NORTHAMPTON  
**GATEWAY**  
STRATEGIC RAIL FREIGHT INTERCHANGE

**STATEMENT OF COMMON GROUND BETWEEN  
THE APPLICANT AND HIGHWAYS ENGLAND**

**DOCUMENT 7.1D**

### Further Statement of Common Ground with Highways England in relation to transport matters and the draft Development Consent Order

Drawing Title  
**M1 J15 OUTLINE DRAINAGE STRATEGY**

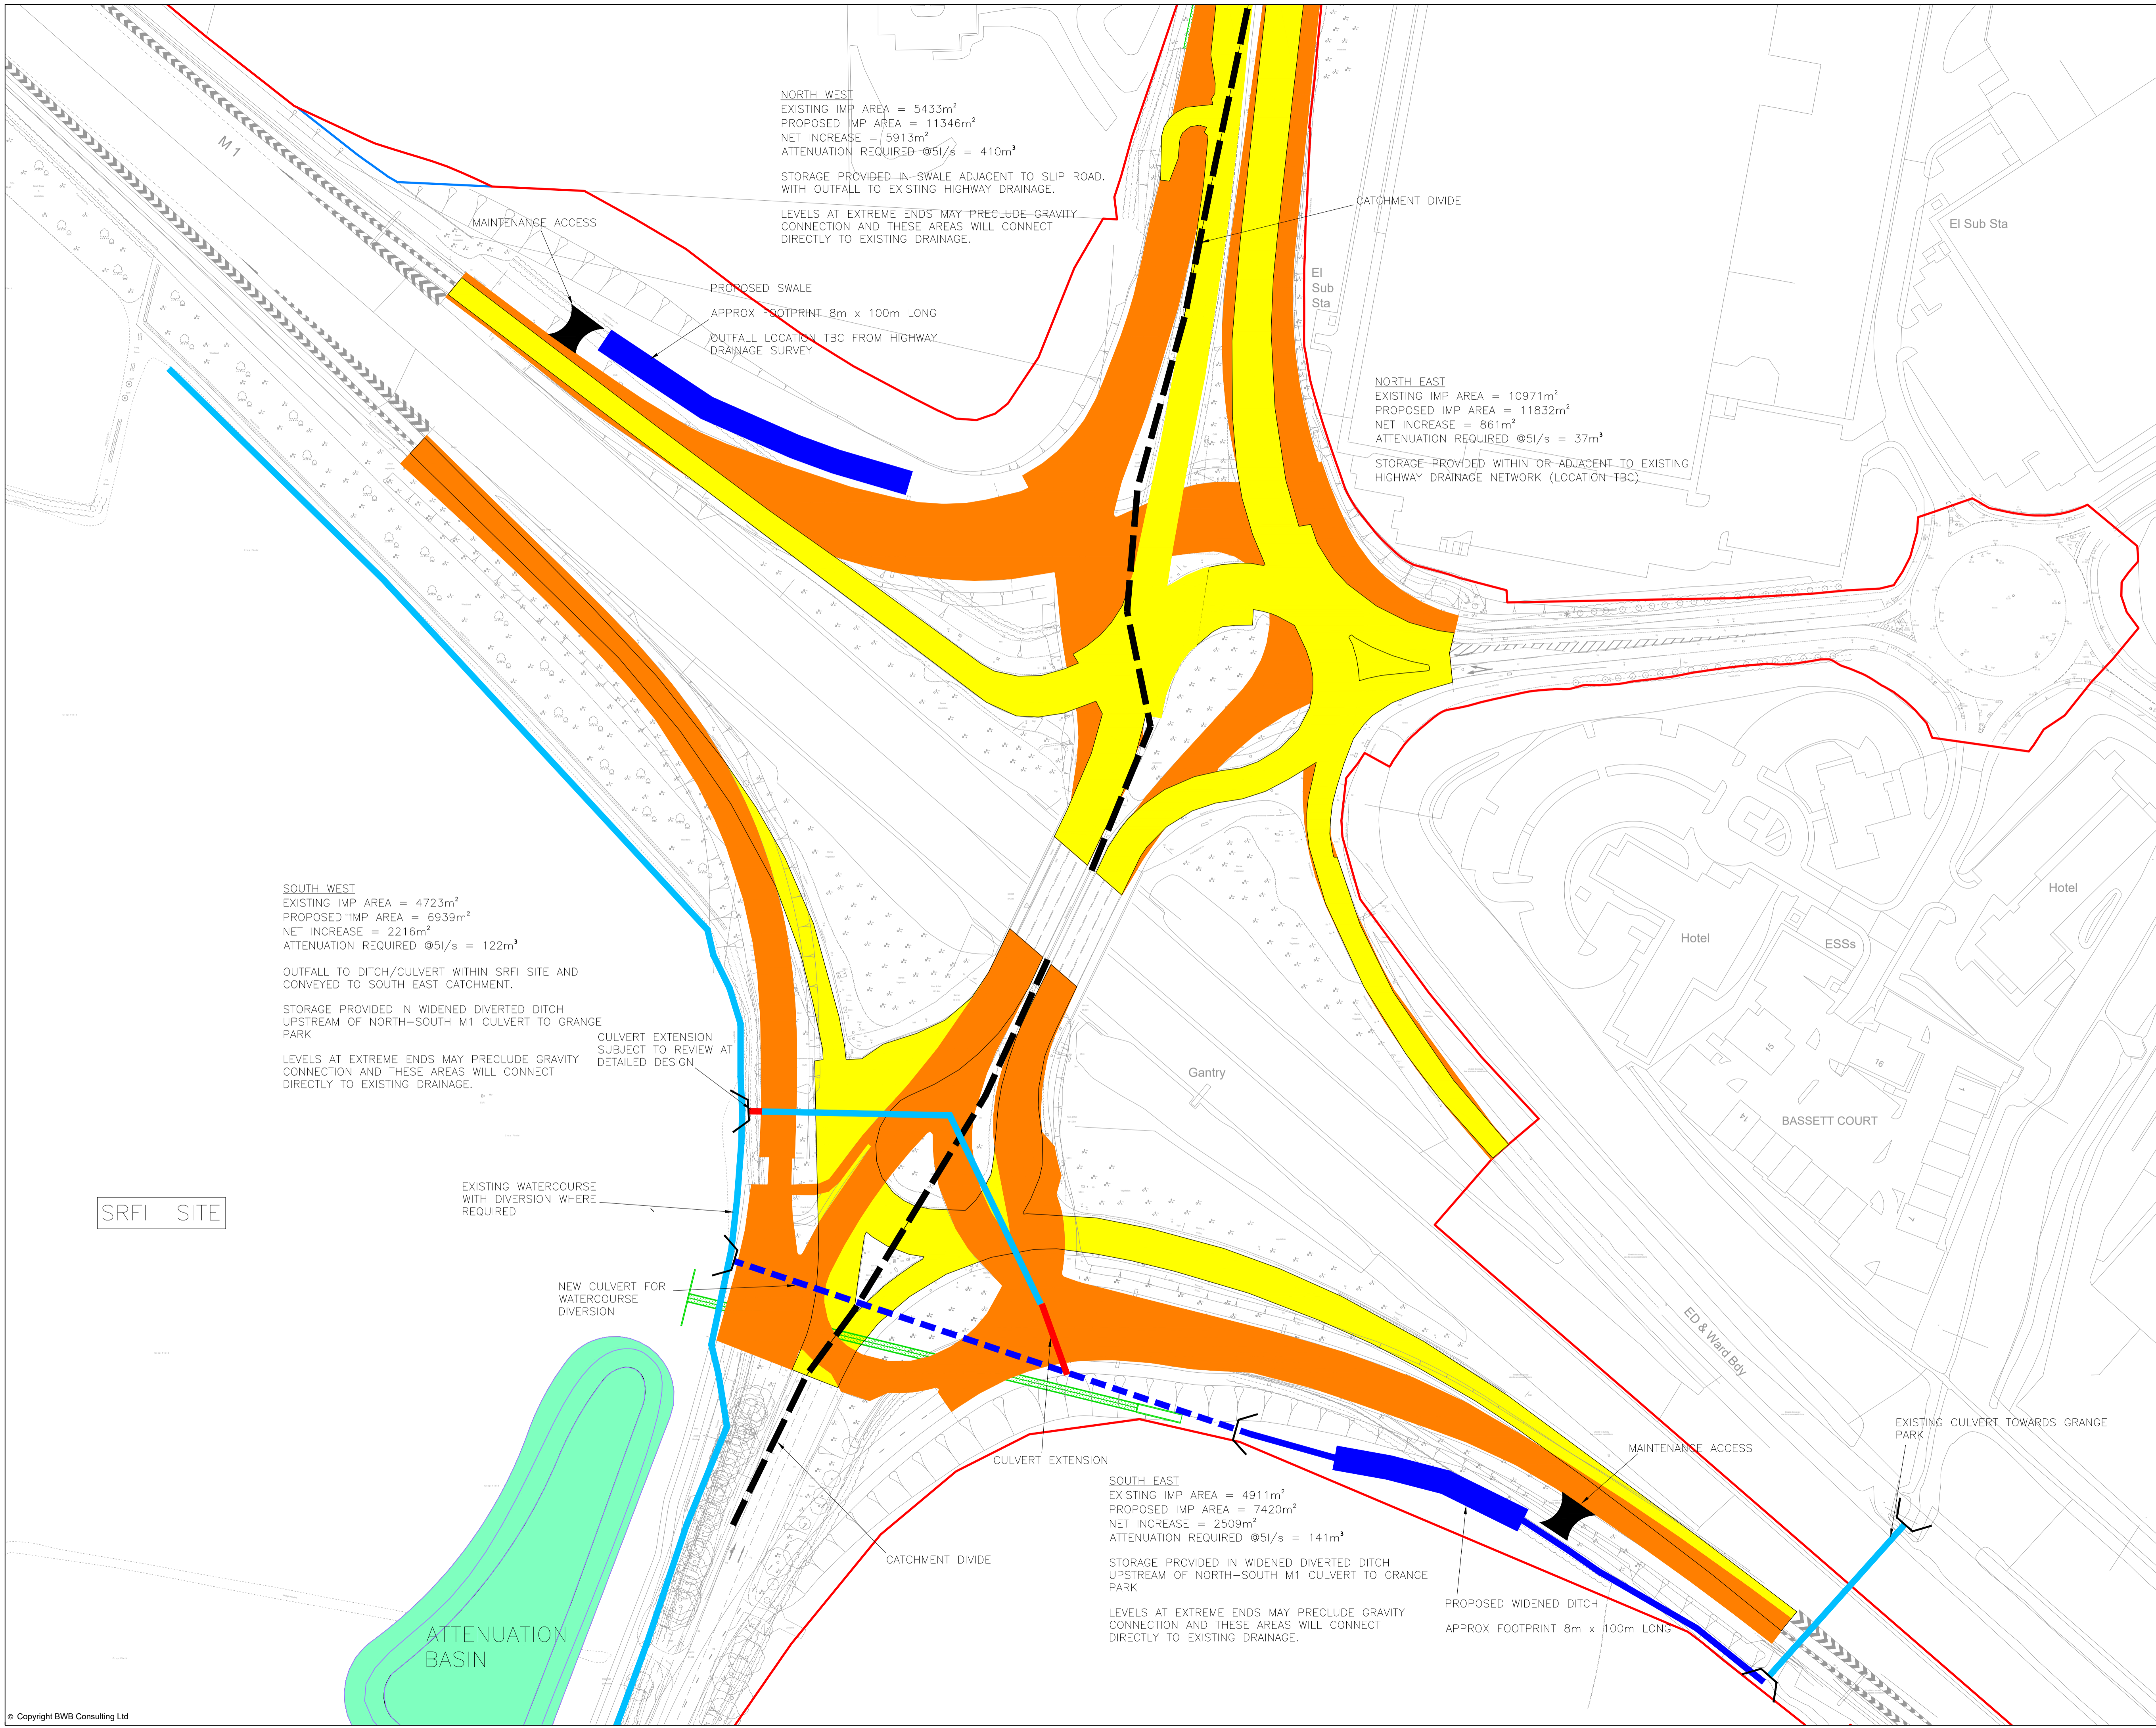
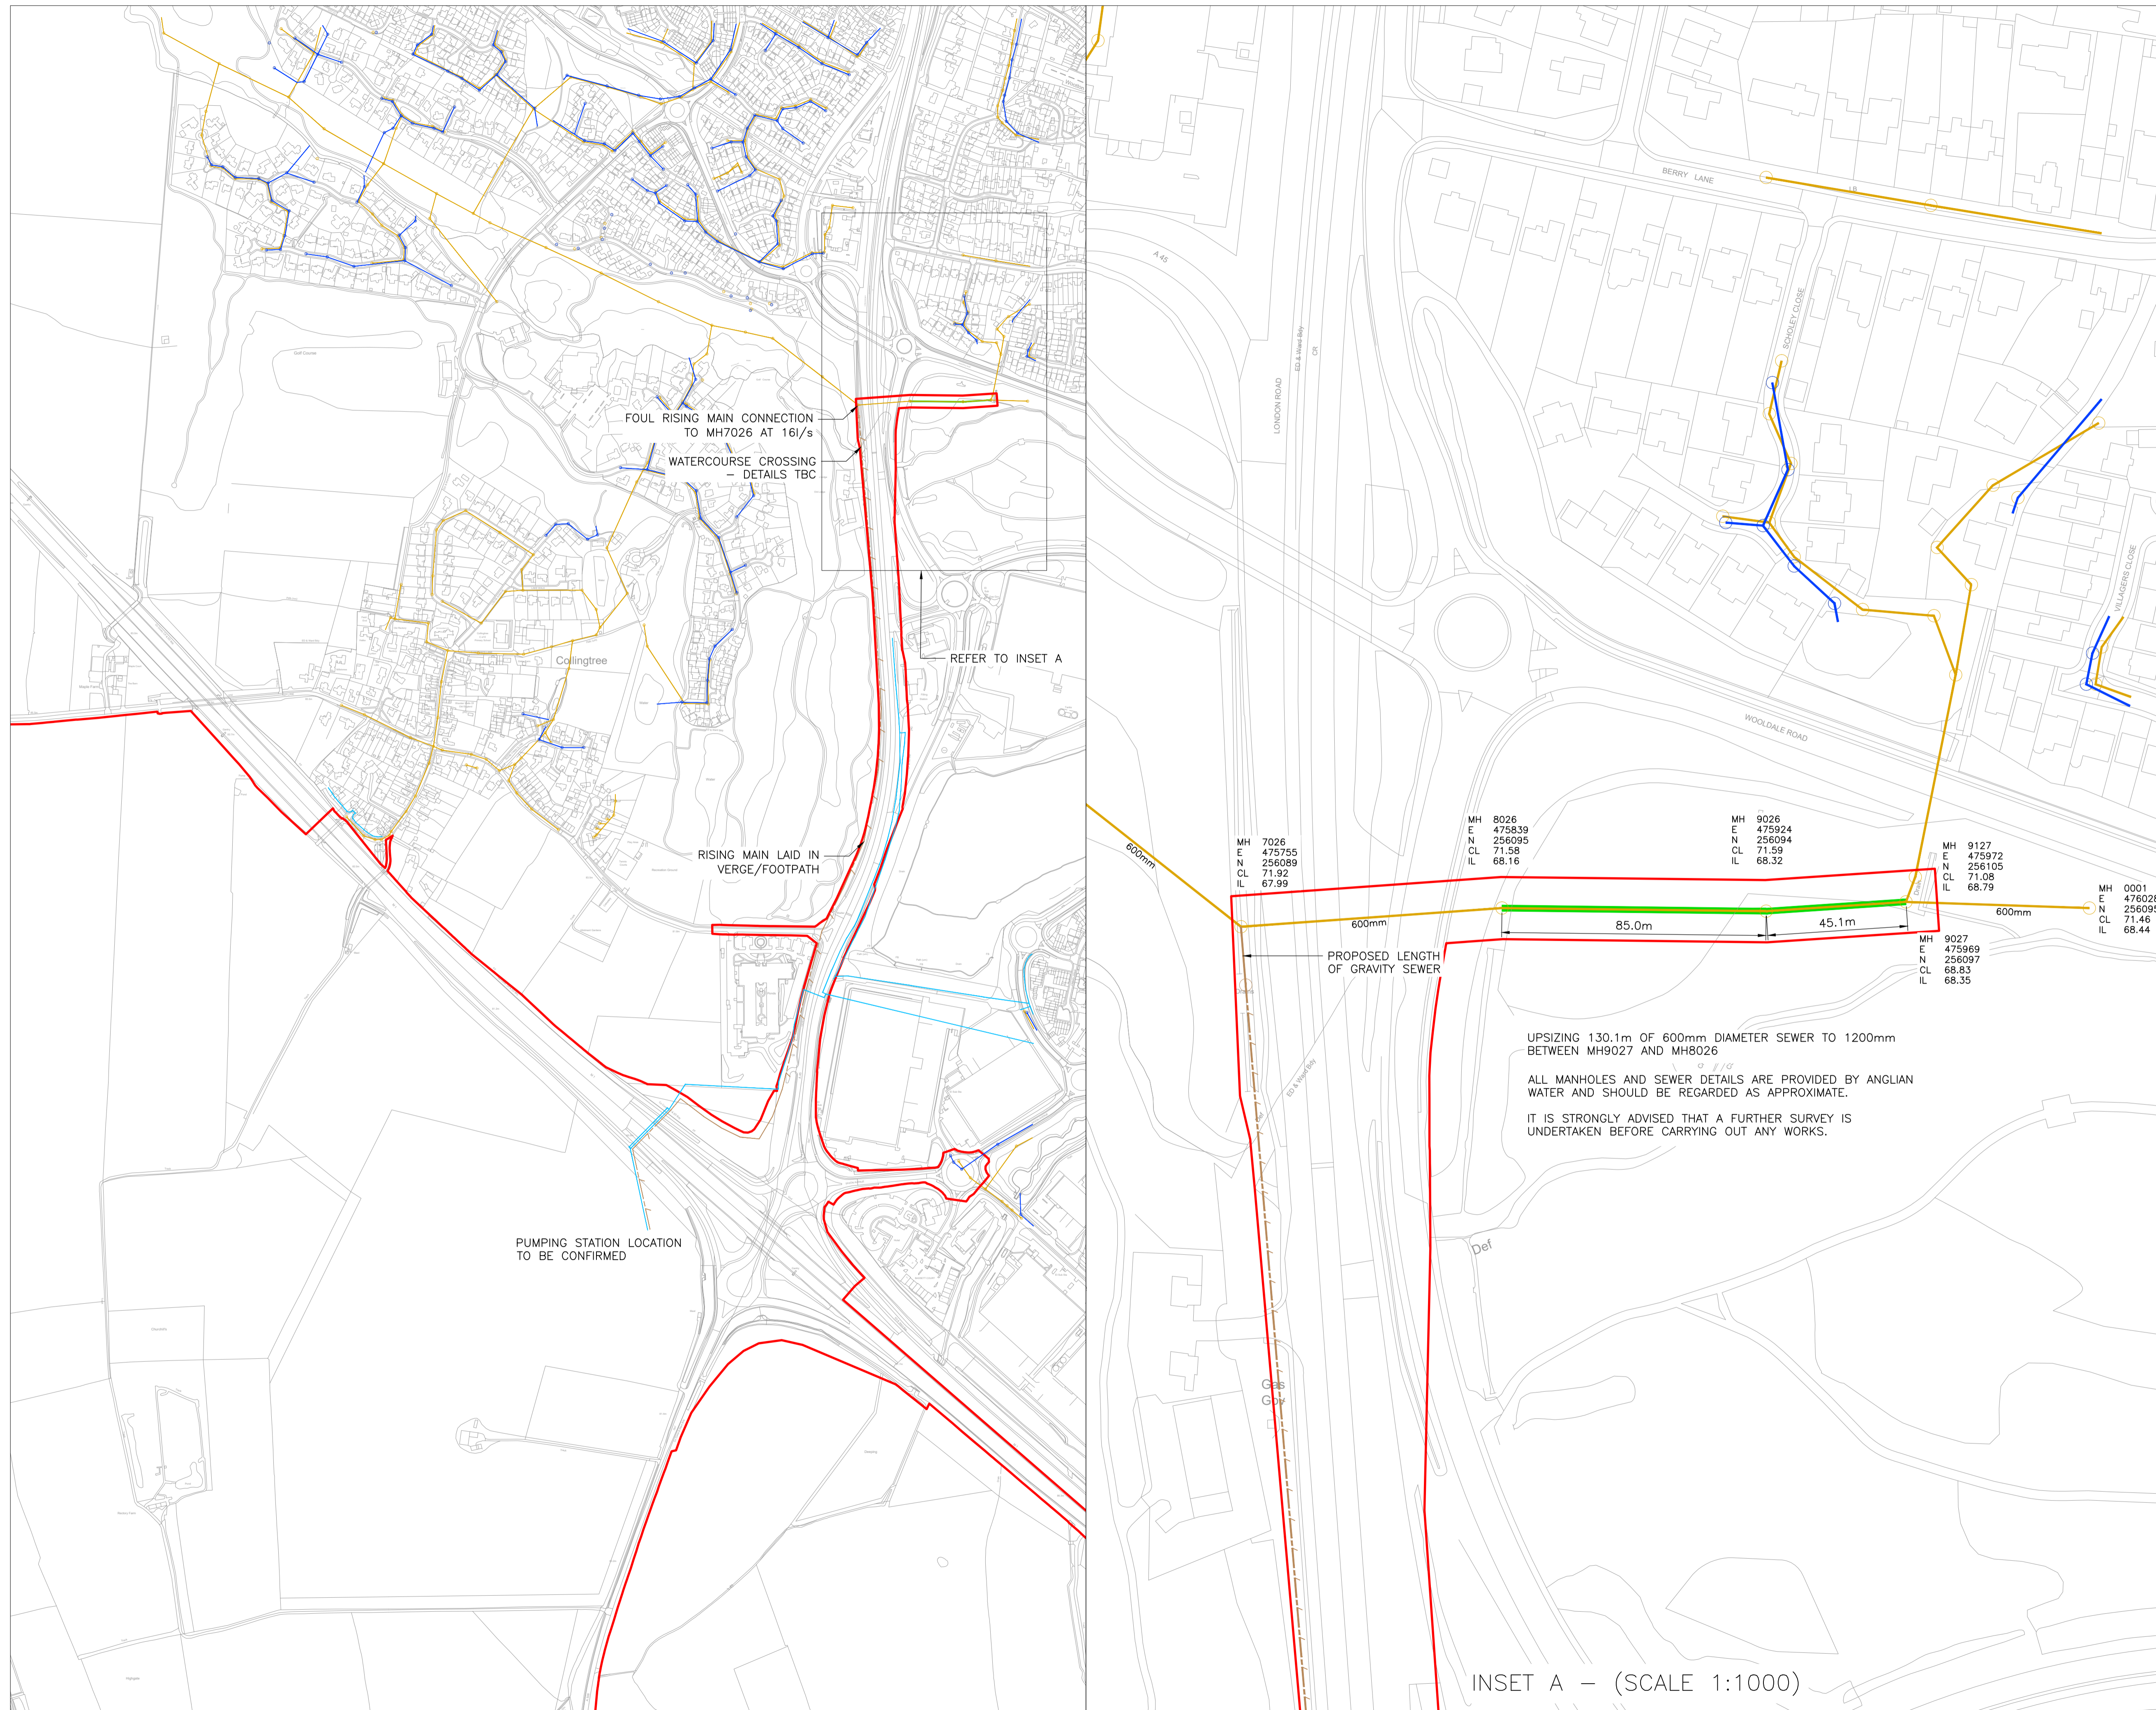
ii) At M1 Junction 15 a new culvert is being provided for the watercourse as shown on the M1 J15 drainage strategy. Hence no assessment of the existing culvert has been undertaken as it will no longer form part of the watercourse. The existing culvert may be retained for highway drainage purposes but that will be confirmed in the detailed highway design. As above for the Collingtree outfall, the agreed drainage strategy confirms that the flow into this watercourse that passes under Junction 15 will not increase as a result of the development. This satisfies the risk of additional flows to the Highways England network. The treatment of the existing culvert is to be proposed and agreed with Highways England at the detailed design stage in accordance with the agreed protective provisions.

2.6 The principles of the SRFI main site drainage strategy, in so far as to how they may impact the strategic road network, are therefore agreed with Highways England.
